Consultation Response from KC, Highways Development Management
2022/91139 land south of Oddfellows Street, Scholes, Cleckheaton, BD19 6NX
Erection of 34 dwellings along with all associated infrastructure, parking, open space and landscaping
Date Responded: 24-10-2022 Responding Officer: Mark Berry Responding Ref: 7-4NE-17

This application seeks approval to the erection of 34 dwellings along with all associated infrastructure, parking, open space, and landscaping at land to the south of Oddfellows Street, Scholes, Cleckheaton.

Drawing Title	Site Plan		
Job-Dwg No	OS 100 - 02	Rev	H

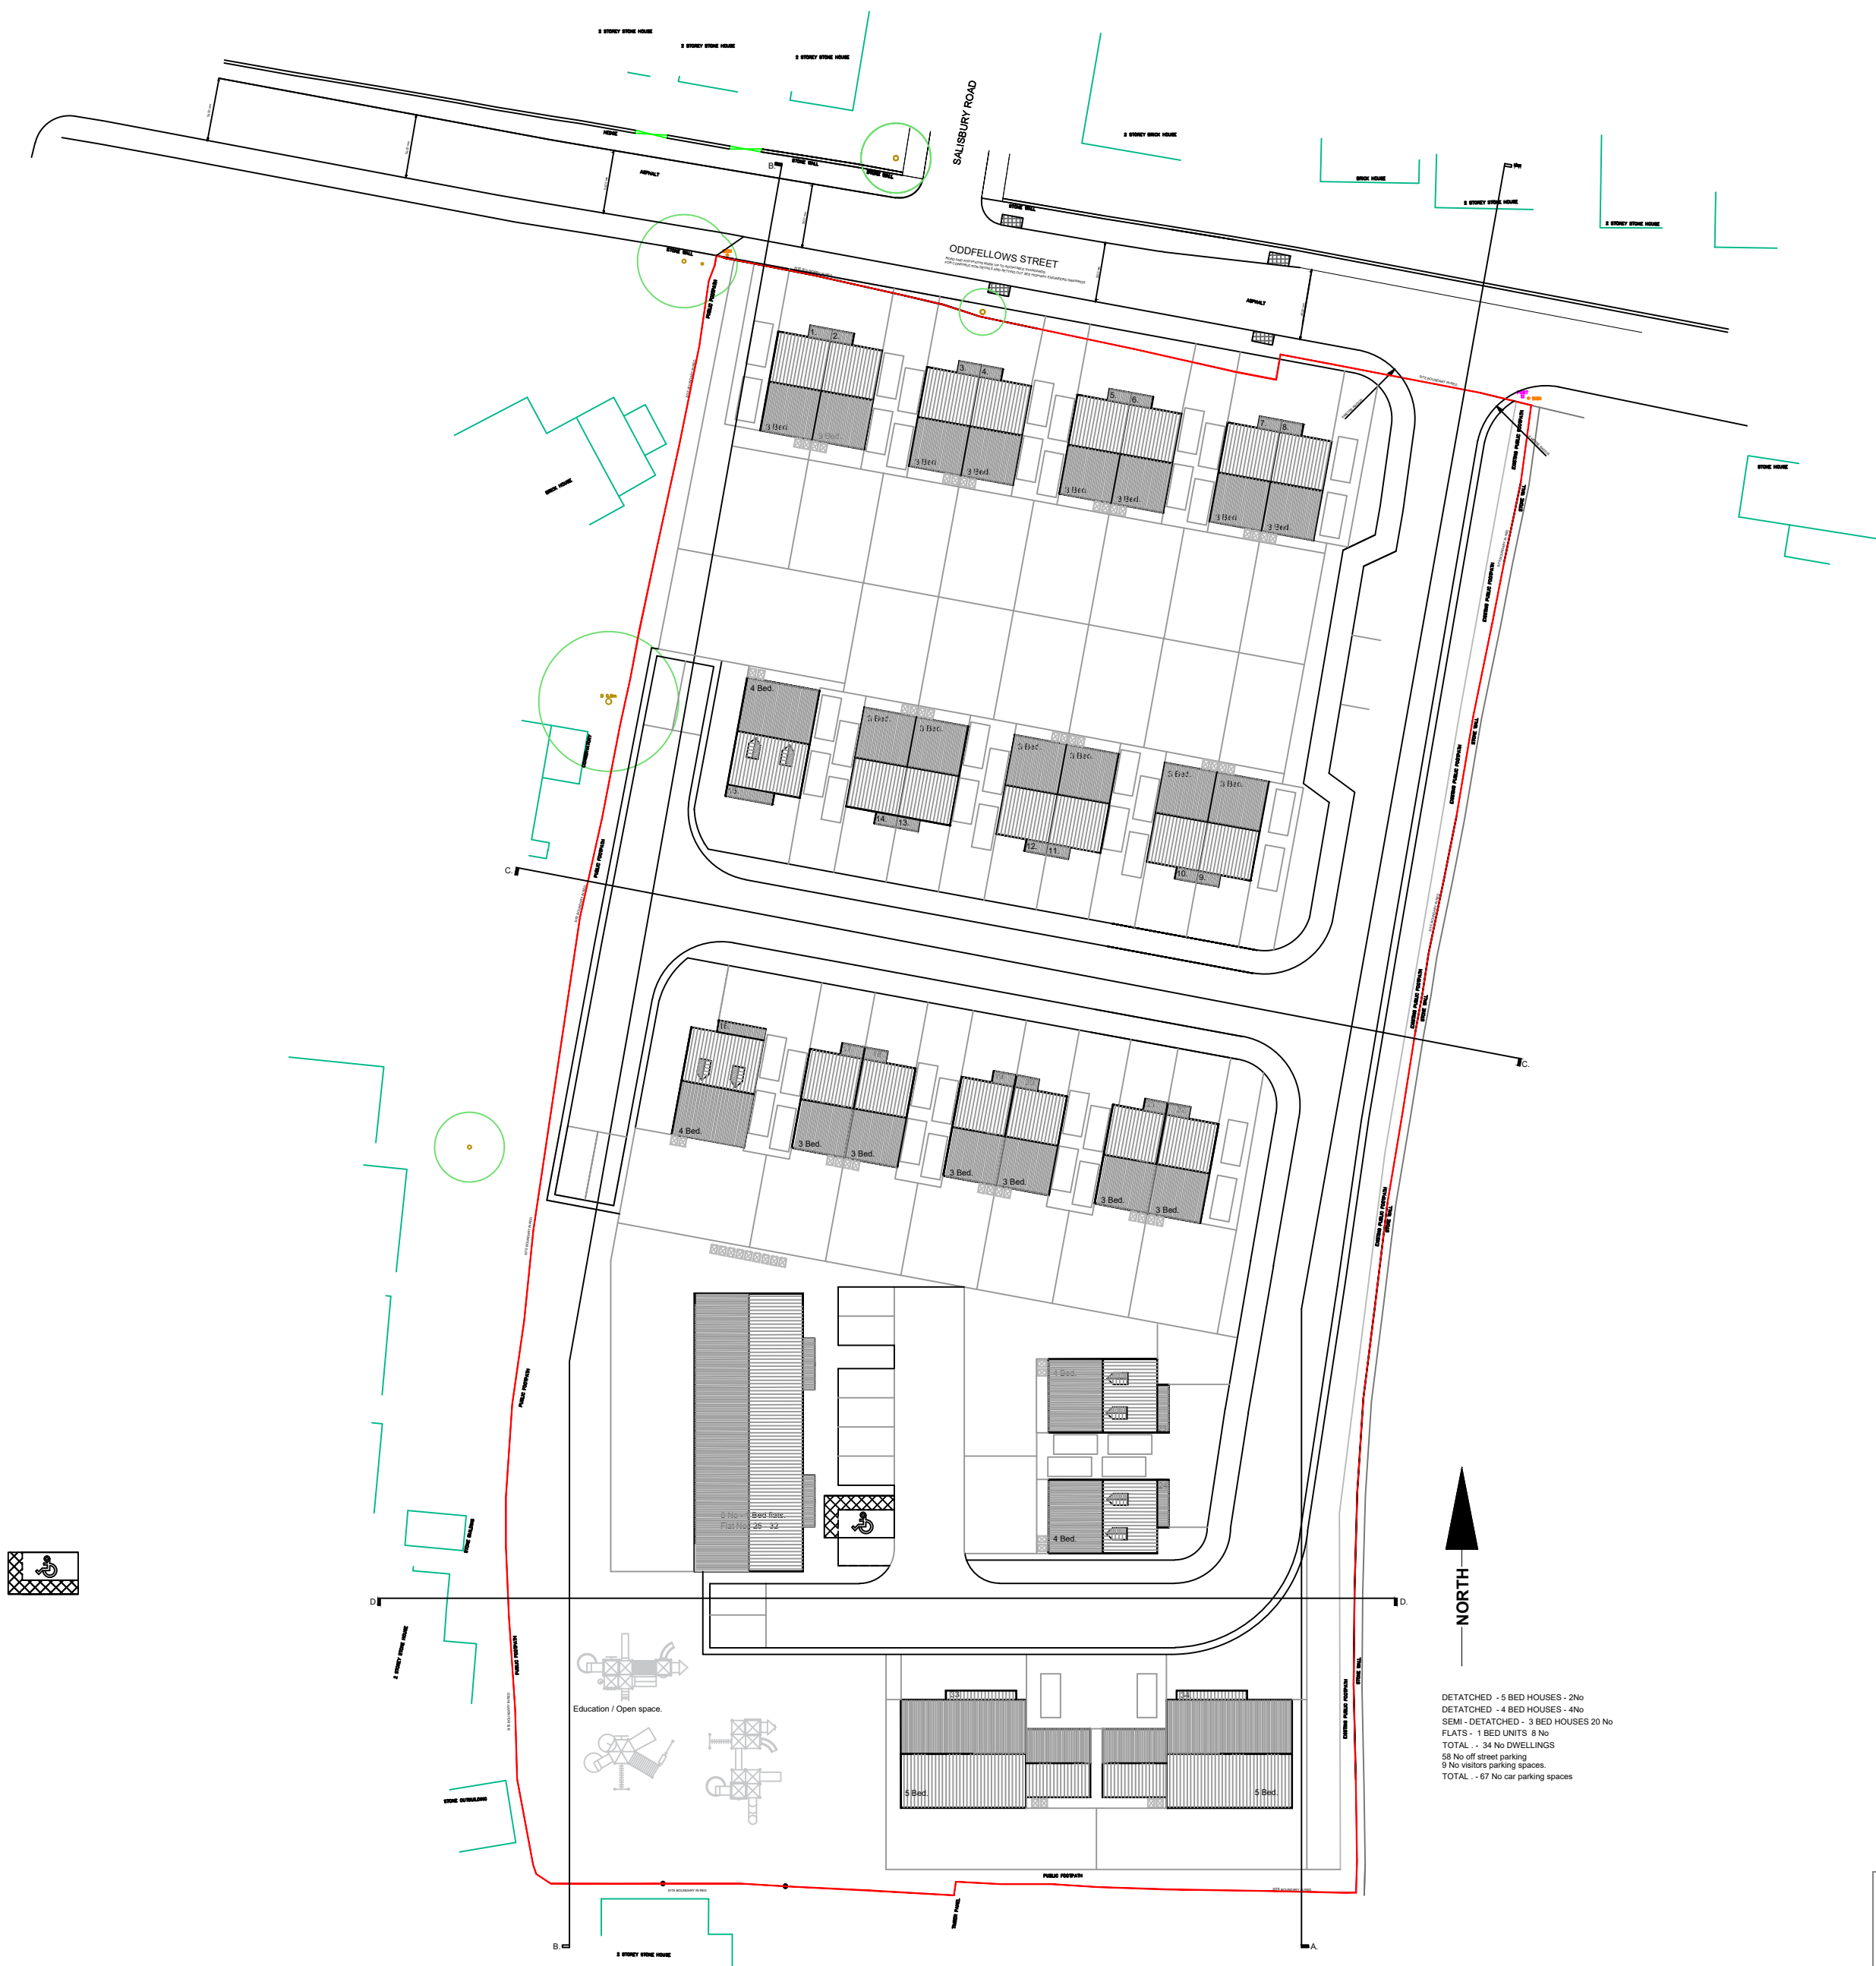
Drawing number OS-100 -02, shows an indicative layout of 34 units, comprising of 2 No detached 5 bed properties, 4 detached 4 bed properties and 20 semi-detached 3 bed properties, along with 8 no 1 or 2 bed flat starter units. PROW --- and --- are shown to be retained along the eastern and western boundaries of the site.

- 1, Driveways to plots 8,9 and 22 too close to junctions
- 2, A footway should be shown to return around the junction radii from the eastern side of the site.
- 3, Footways should be provided to both sides of the road to link to plots 33 and 34 and to the public open spaces and around the proposed turning heads.
- 4, One visitor space per 4 dwellings is considered appropriate. One cycle space per unit is recommended. If on street visitor parking is proposed the swept path vehicle tracking should show the parking will not obstruct the refuse vehicle at all feasible locations

5, Swept paths should be provided which demonstrate that an 11.85m refuse vehicle can enter and exit the site from Oddfellow Street and turn within the site. All schemes must incorporate reasonable tolerances and safety margins. A good starting point is to allow 0.5m clearance to kerbing or vertical obstructions on each side of the swept path. Designs should therefore, where possible, aim to cater for vehicles larger than the above minimum standards. The junction radii shown are unlikely to be sufficient to accommodate these turning manoeuvres.

6, No details of gradient's are provided. The desirable maximum carriageway longitudinal section gradient on all adoptable shared surface carriageways is 1 in 20 (5%). If this is not achievable, then the specific circumstances should be discussed with the Council to address potential mobility and safety implications. A gradient no steeper than 1 in 10 (10%) is preferred.

The gradient of a non-priority route on the approach to a junction should be a gradient of 1 in 40 (2.5%) for the initial 10 metre length with an absolute maximum of 1 in 25 (4%).

7, Bin collection points should be provided to all dwellings to enable bins to be presented on collection day without either obstructing the highway or proposed driveways.
